From: Sue Howell <Sue.Howell@arun.gov.uk>
Sent: 15 November 2019 14:41
To: Planning.Responses <Planning.Responses@arun.gov.uk>
Cc: Richard Castro-Parker <Richard.Castro-Parker@arun.gov.uk>
Subject: RE: Planning Consultation on: AB/88/19/PL

Comment from Greenspace,

APPLICATION NO: AB/88/19/PL

Description of Works: 38 No residential apartments (9 No 1-bed units & 29 No. 2-bed units) along with access, off-street parking, amenity space & enhancements to the local footpath network.

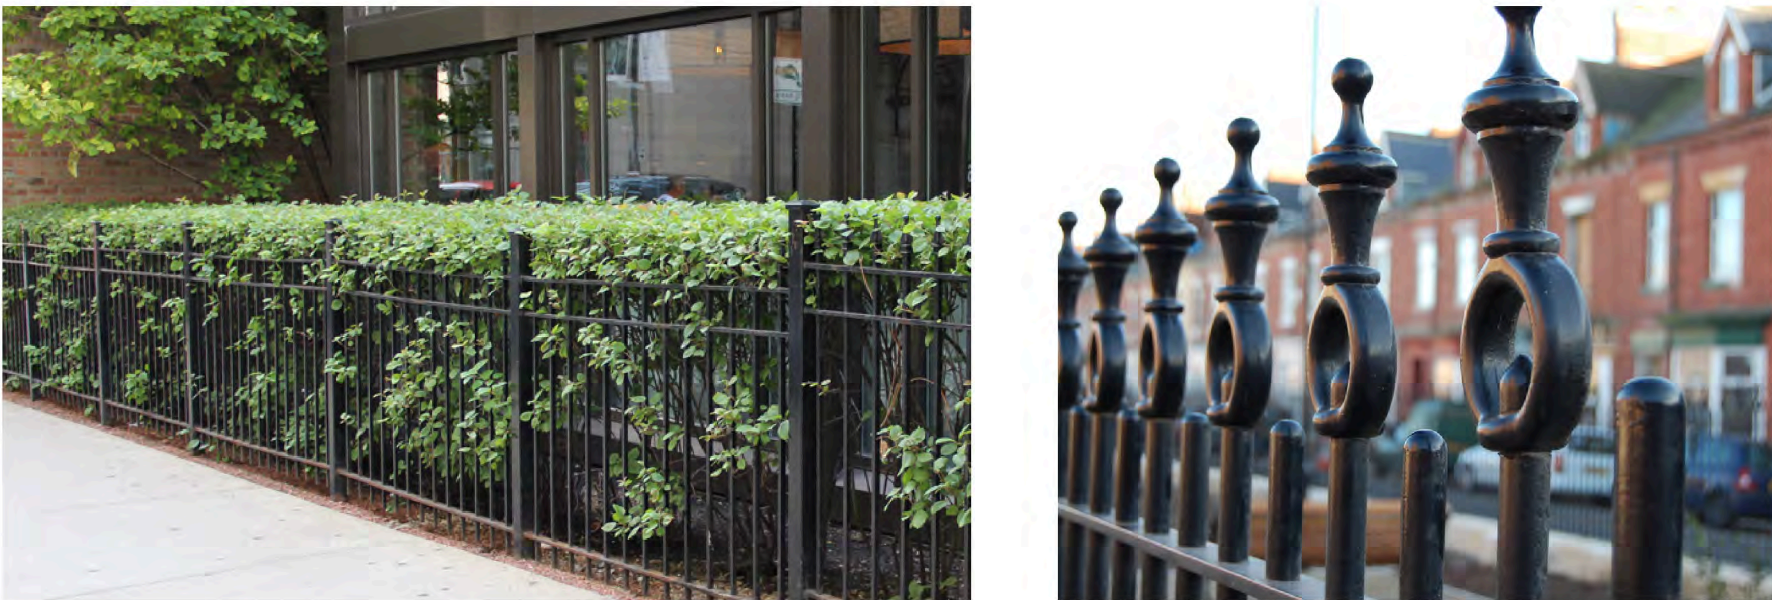
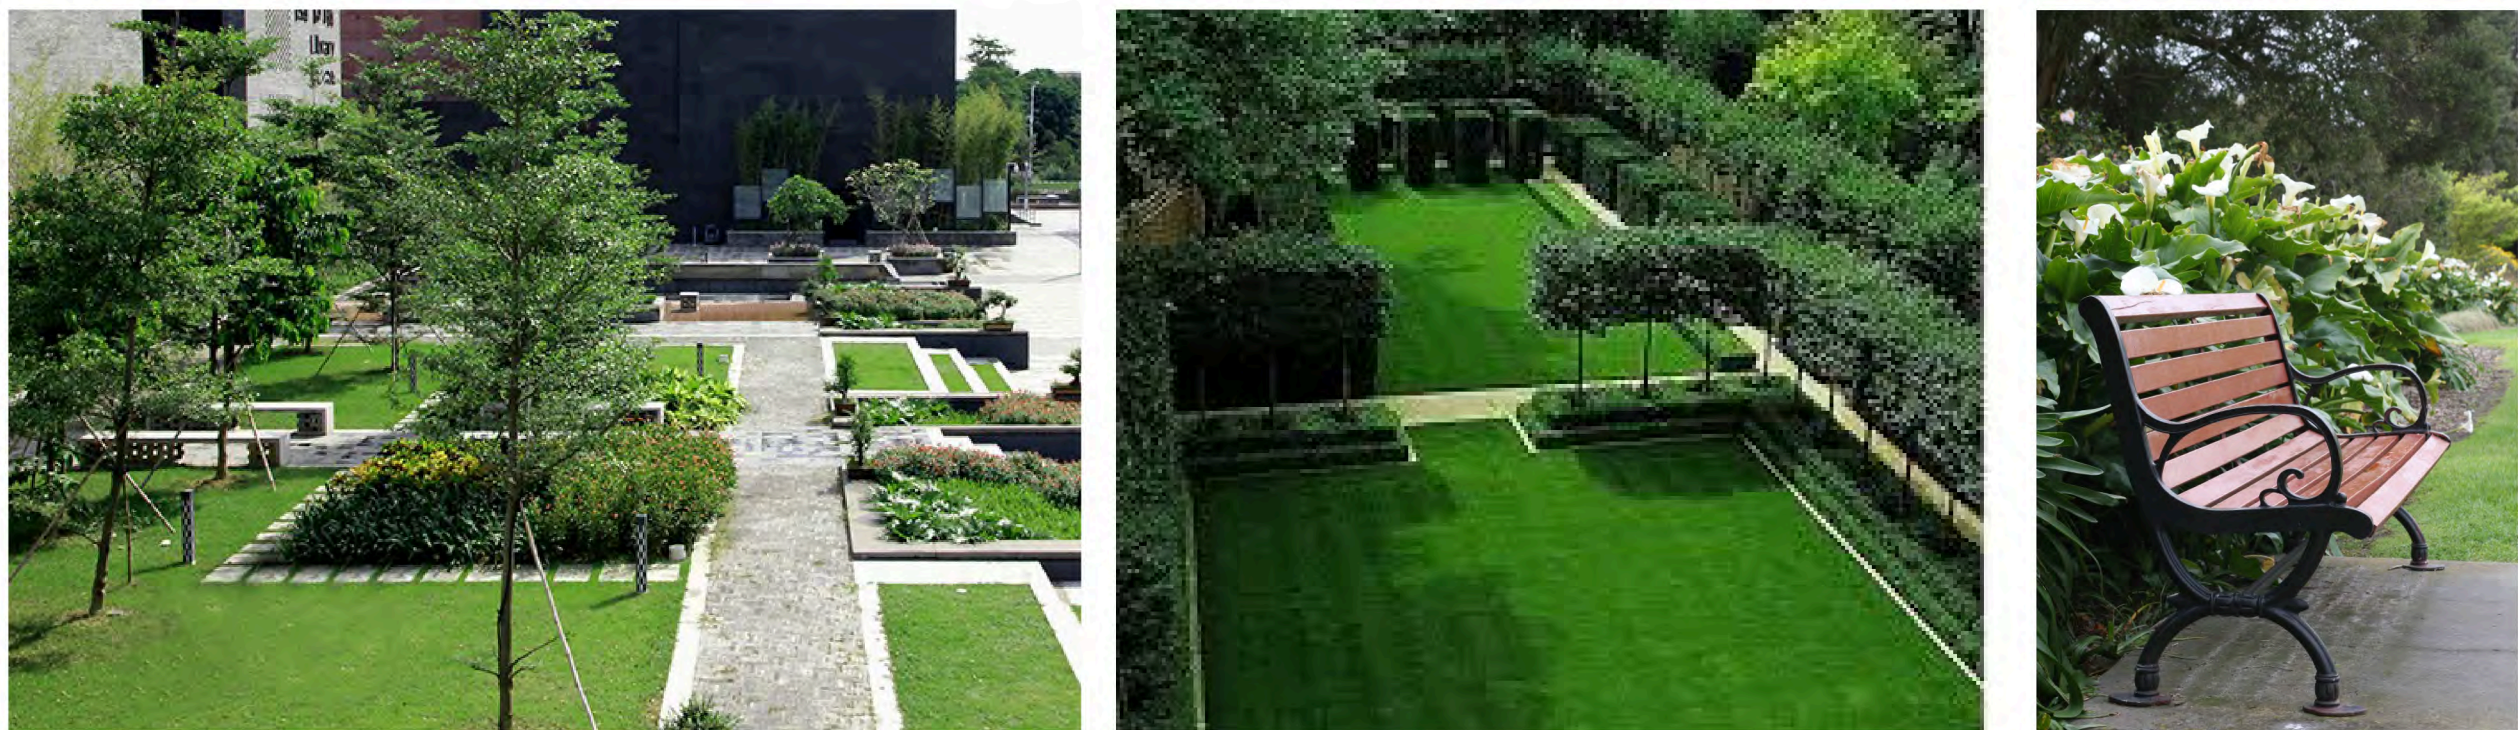
Indicative landscape proposals have been shown in dwg CSA/4163/IC4 Rev D, which would appear to propose a pleasant scheme forming both formal outdoor areas and incorporating with native edge planting which will be suitable for location. Further detail will need to be submitted or at least conditioned with any decision for the requirement of the submission of a full landscape scheme for approval, detailing actual quantities, species choice, position, densities and size at time of planting. This should be plotted in plan and list form and in relation to the trees and vegetation to be retained in the locale. These details are required to assure the proposals are appropriate to its setting and to ensure that appropriate screening is provided, maintaining and uncompromising the setting and ensuring that the proposals fit within the area.
